County File: OAR2355  
City of Fountain File: ODP-23-003  
Re: Corvallis Overall Development Plan Amendment No. 1  
To: Kristy Martinez, Planning Supervisor

Engineering has the following comments on this Final Plat and Final Drainage Report (documents dated 2023-2024), mainly regarding effects of drainage on offsite adjacent unincorporated County areas.

**CORVALLIS FILING NO. 1**  
**FINAL PLAT**

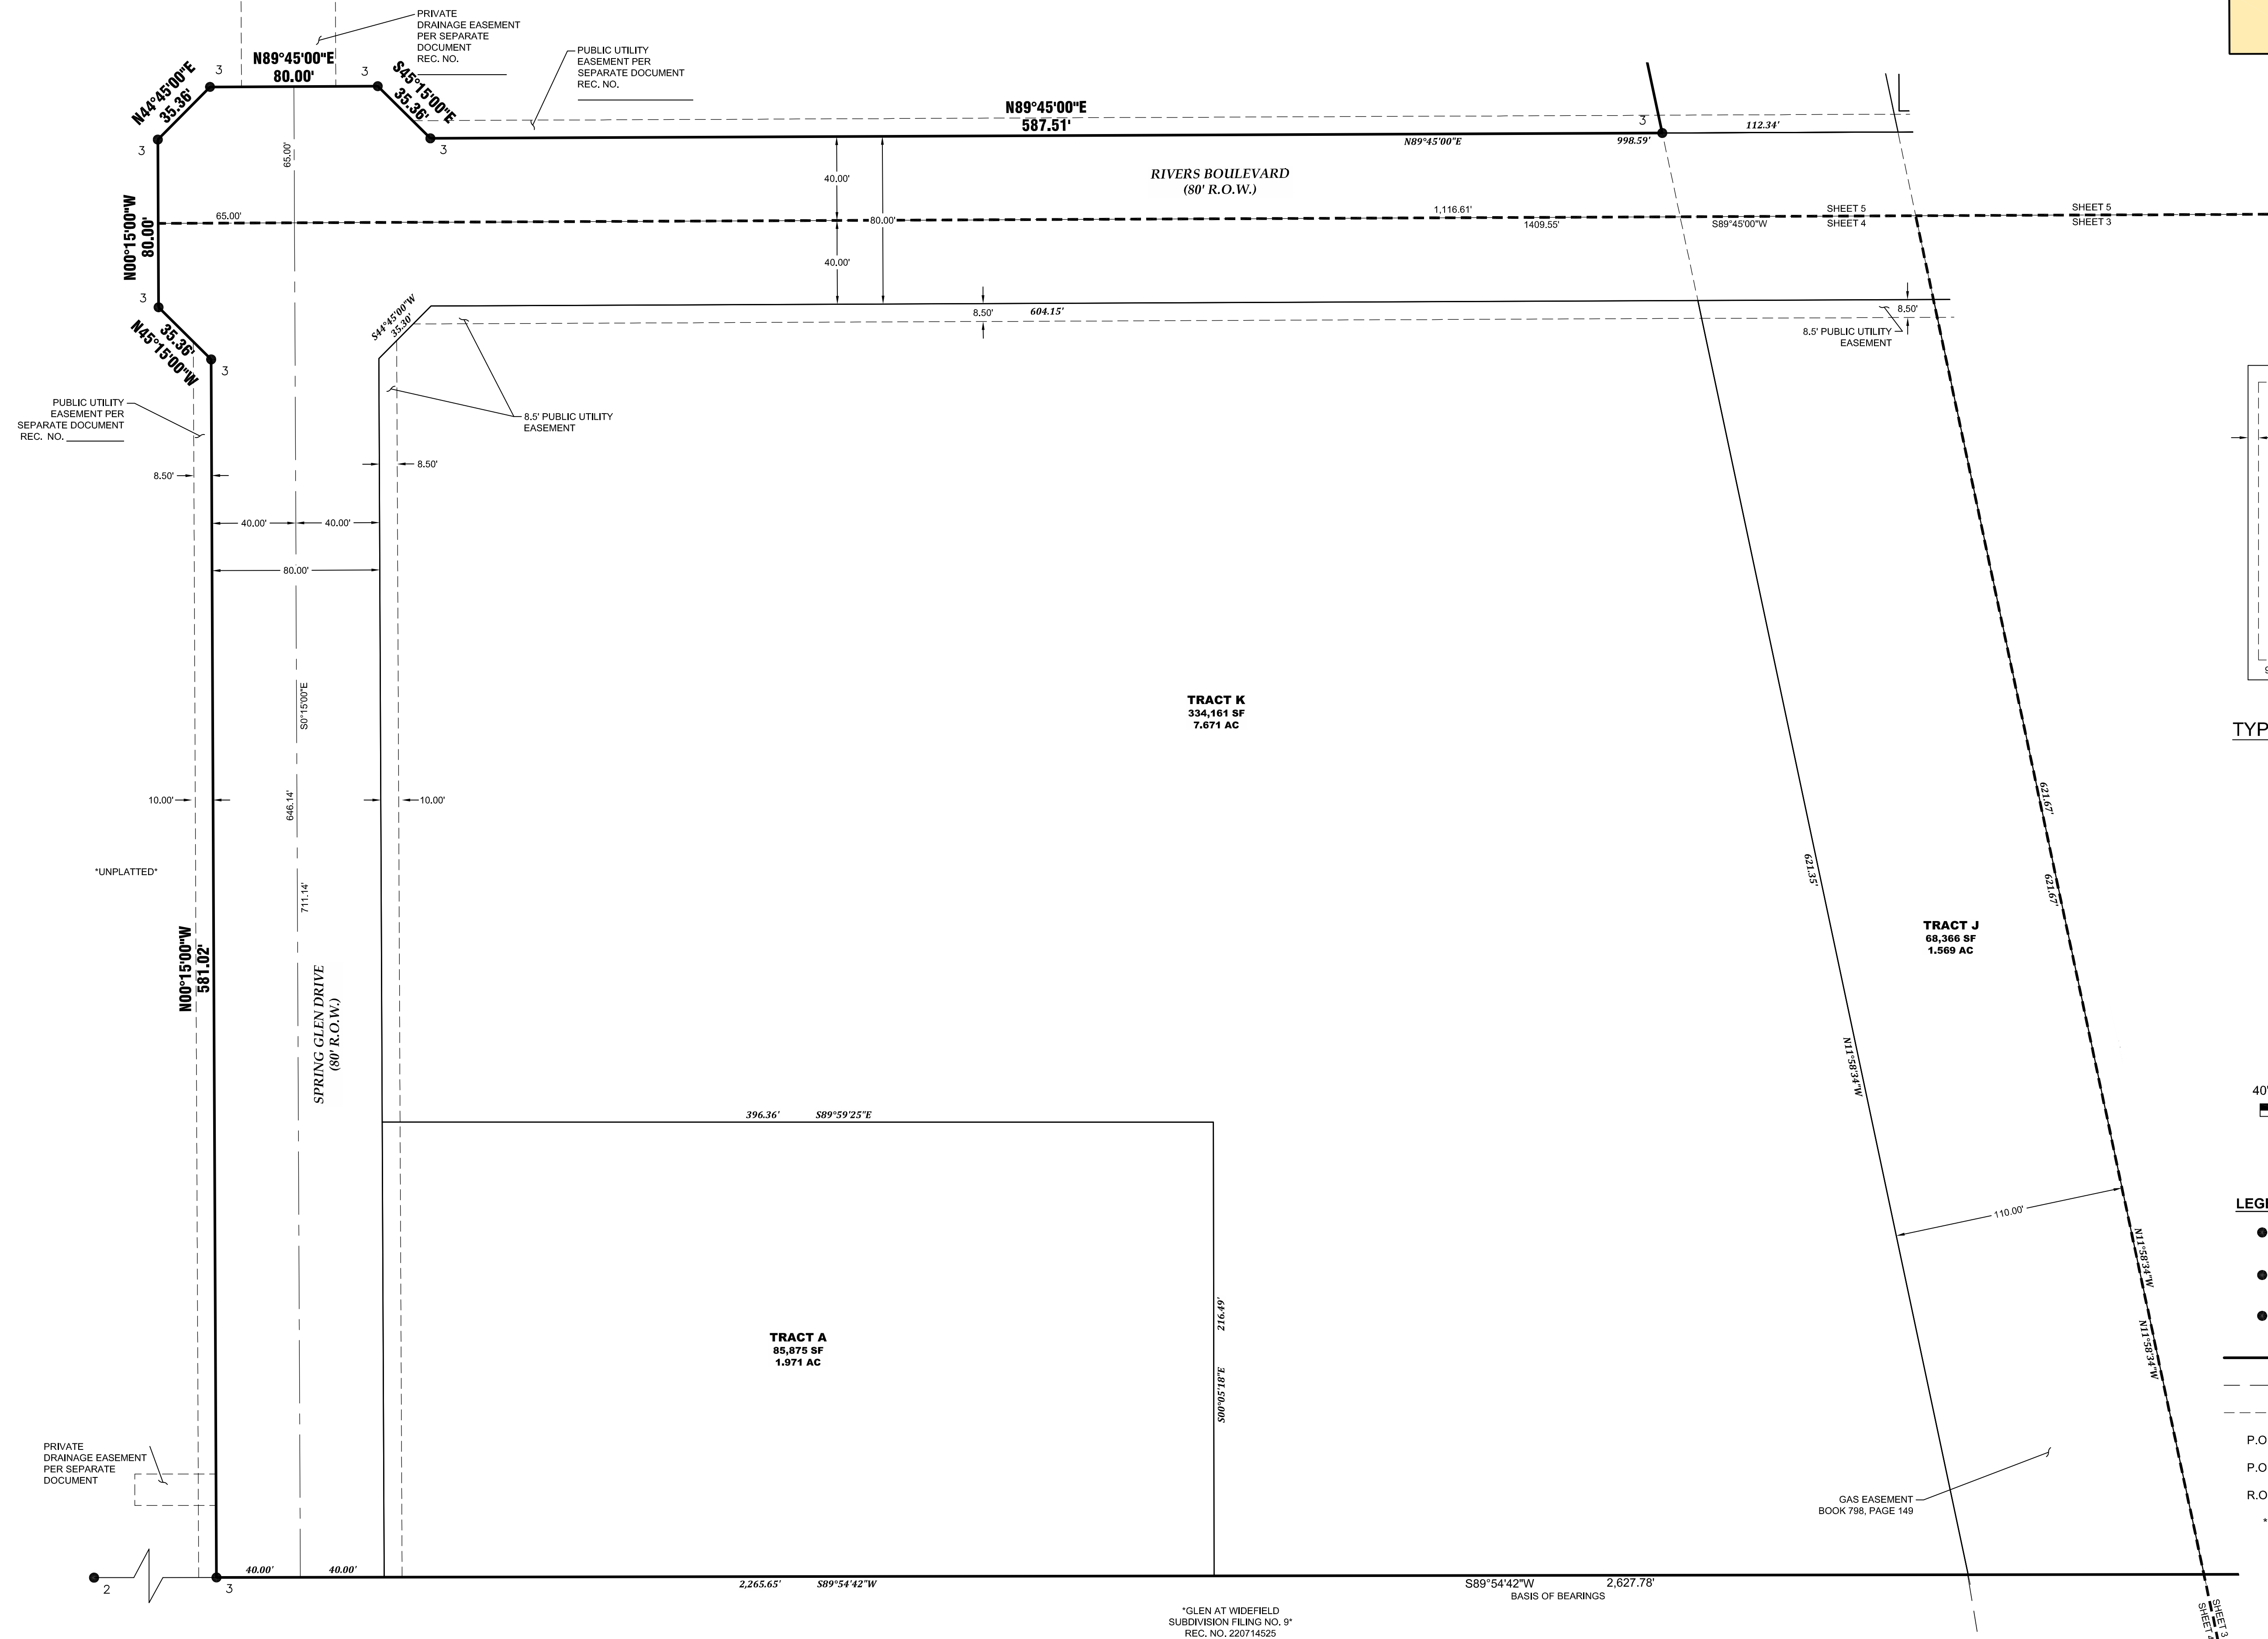
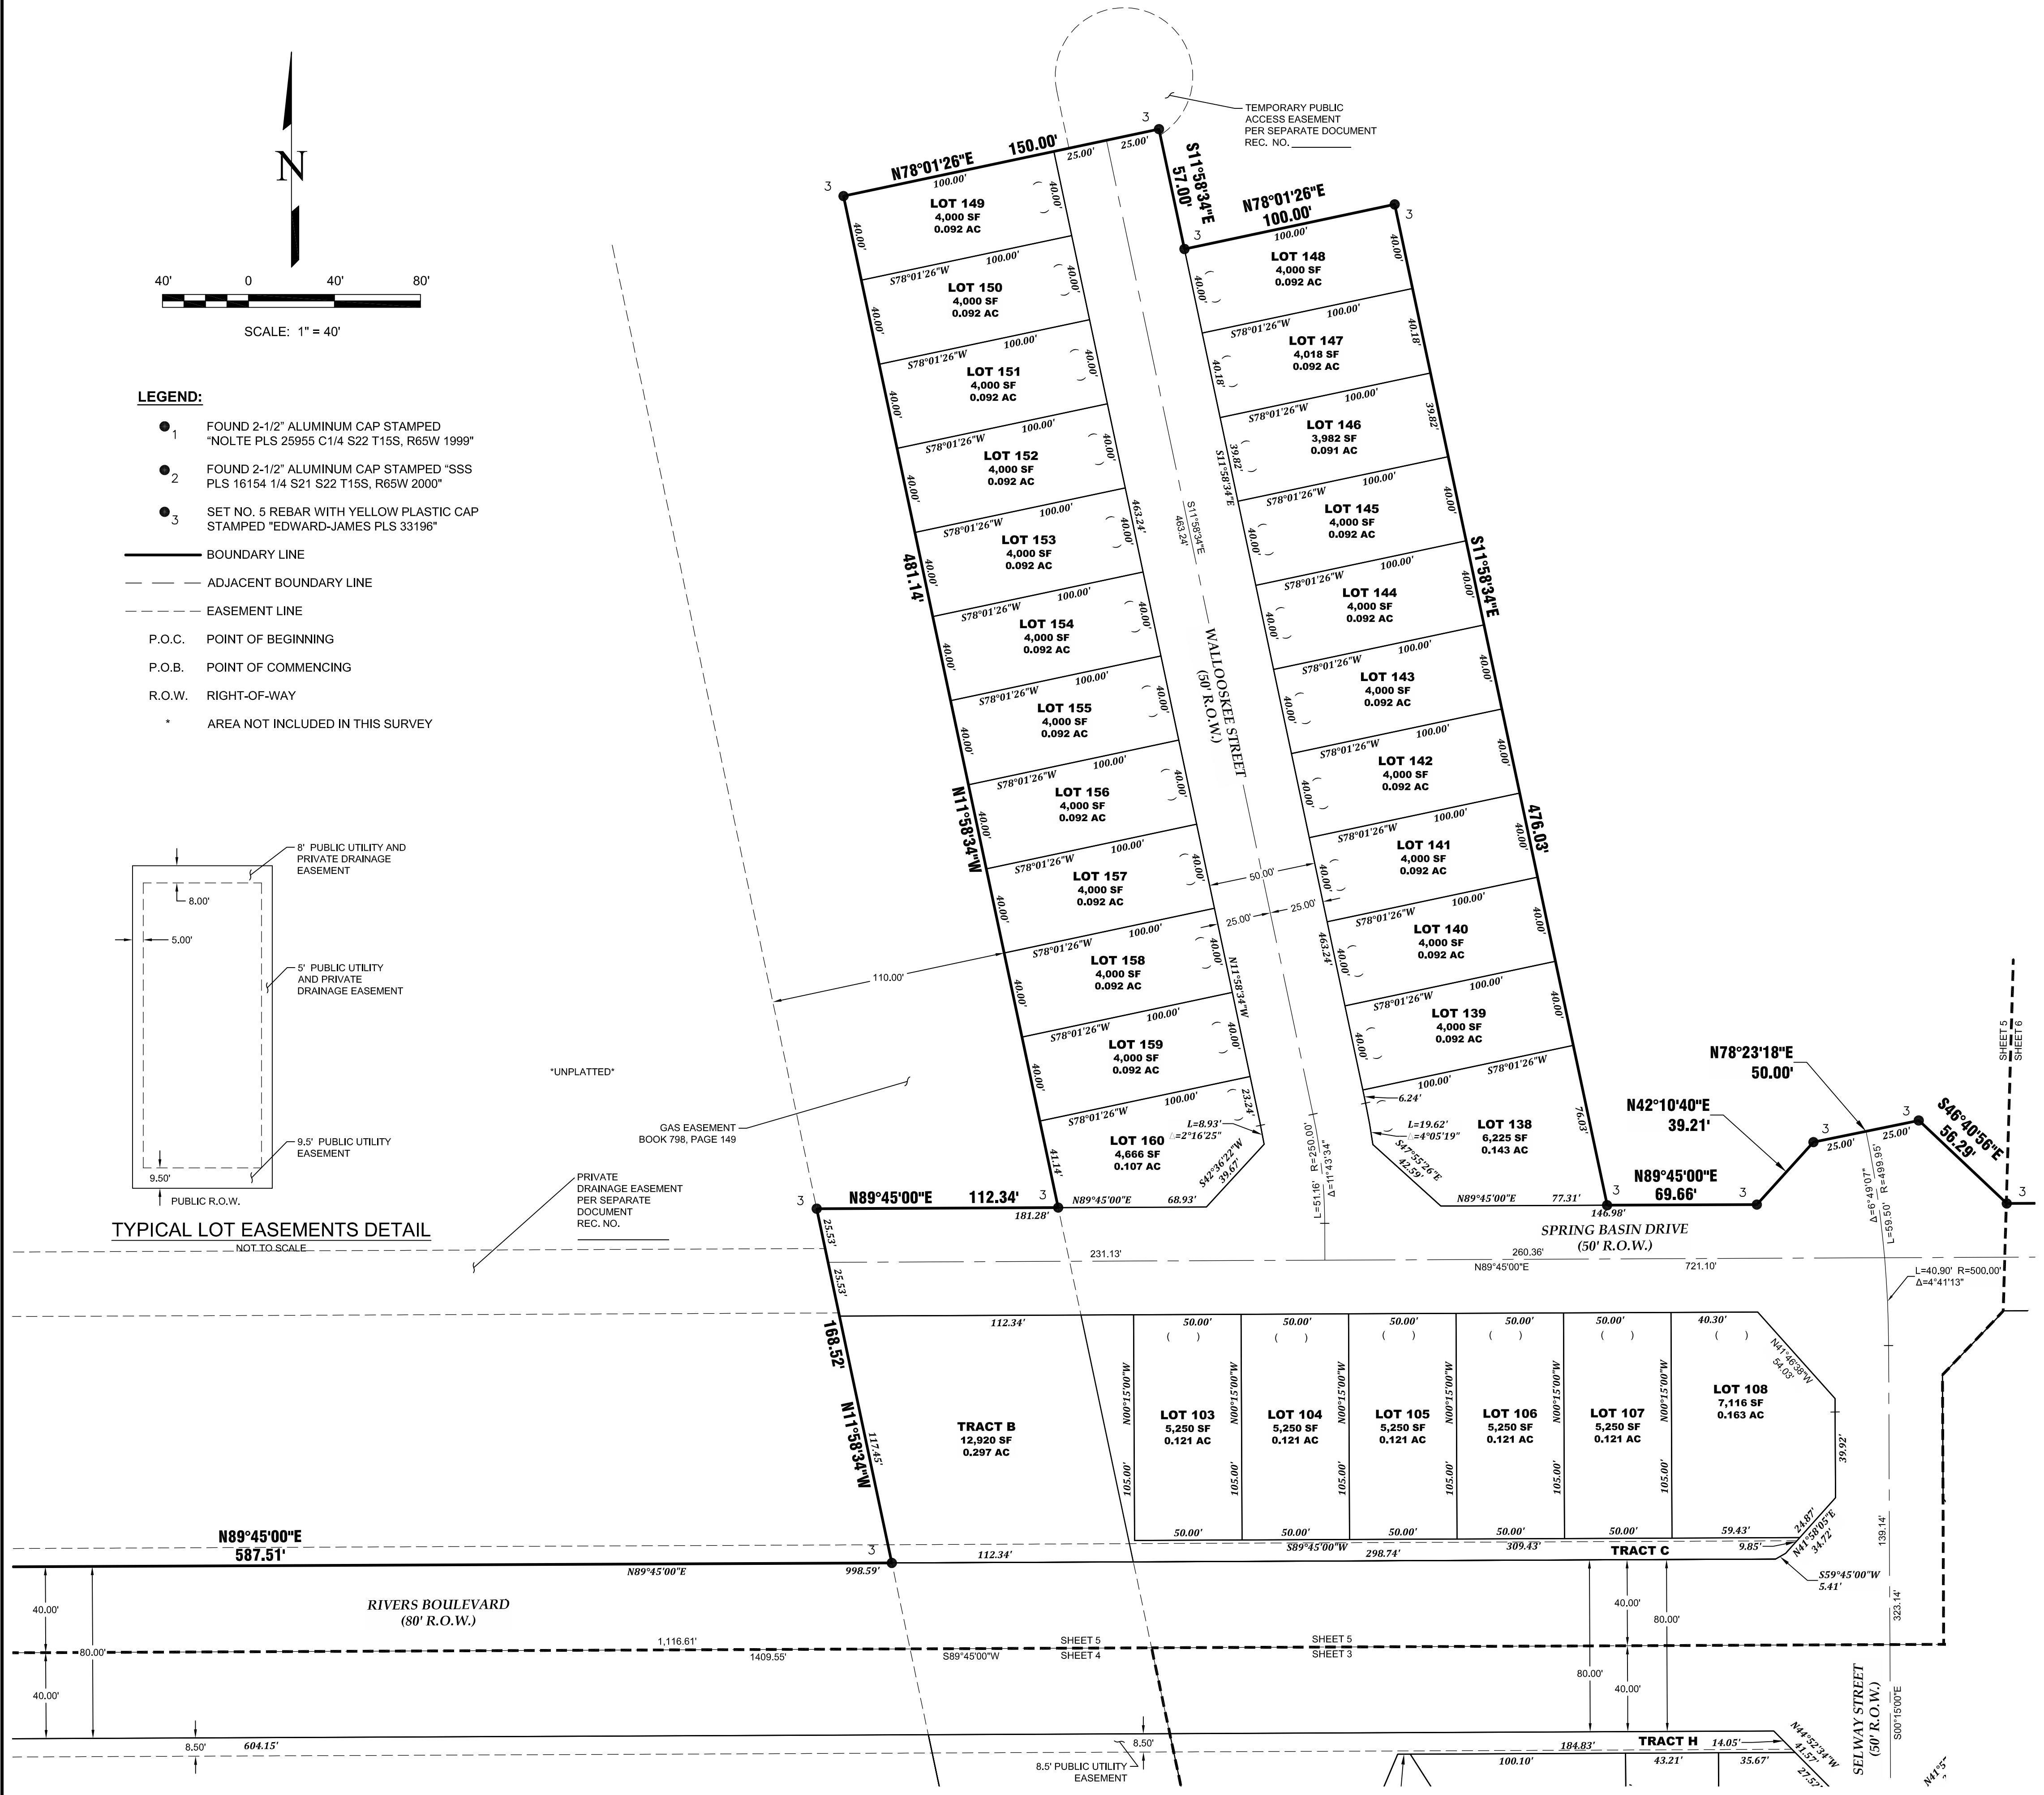
- See drainage plan redlines. (Adjust CDs accordingly.)
- See plat redlines regarding tract label.
